**16850 Stepler Road**  
**Traffic Study Letter**  
PCD File No.

El Paso County, Colorado

Revise to Traffic Study Memorandum

April 20, 2023

FIGURE 7
 16850 STEPLER ROAD
 EL PASO COUNTY, COLORADO
 2026 TOTAL TRAFFIC VOLUMES

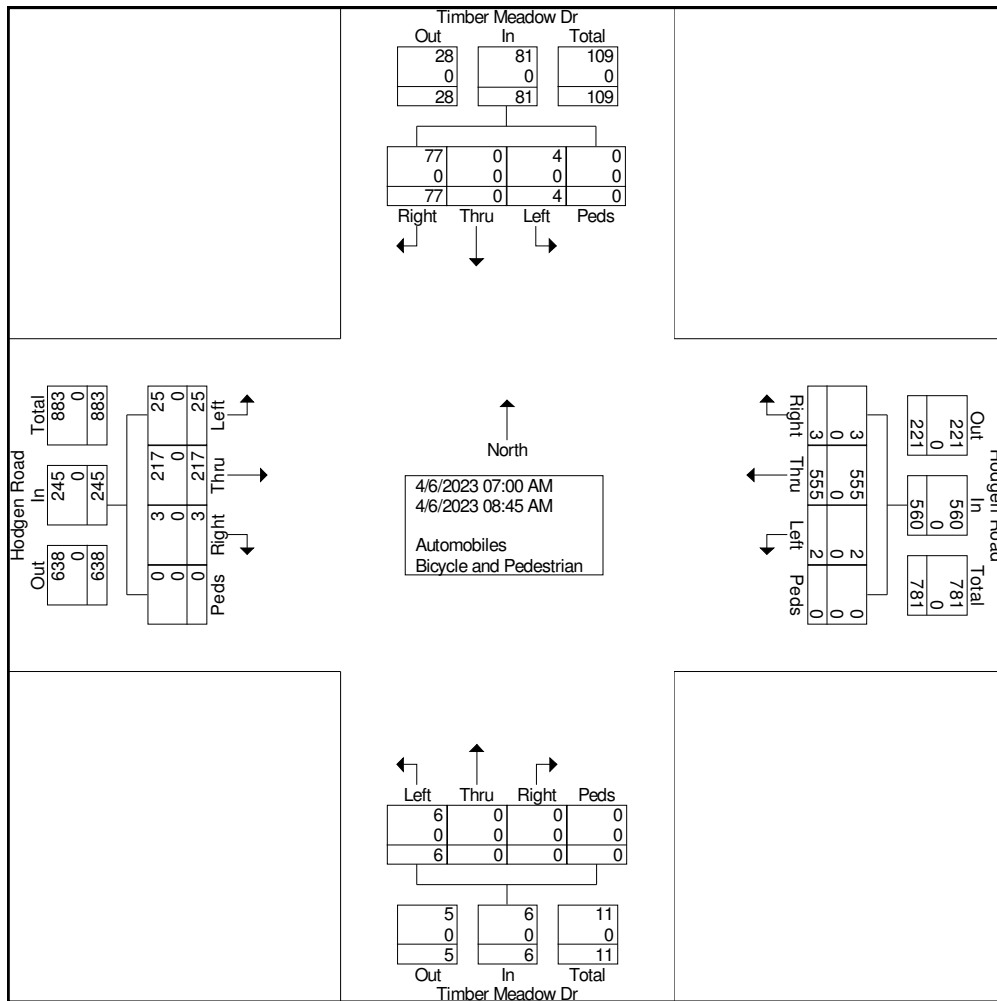
-Provide analysis of turn lane requirements at Timber Meadows and Hodgen. Per the total traffic volumes (figure 7) it appears that the threshold for a southbound dedicated right turn lane on Timber Meadows is met. Provide recommendations whether a dedicated right turn lane should be installed or if the queuing and widen radius that was allowed in the first fillings of Settlers ranch is sufficient. (previous TIS from Settlers Ranch will be uploaded onto EDARP for your use. See page 2 #7)

An evaluation has been provided for the potential need for a southbound right turn lane at the Timbers Meadow and Hodgen intersection. The pertinent information from page 2 of the original 2004 Settlers Ranch Traffic Memorandum has been documented in the study.
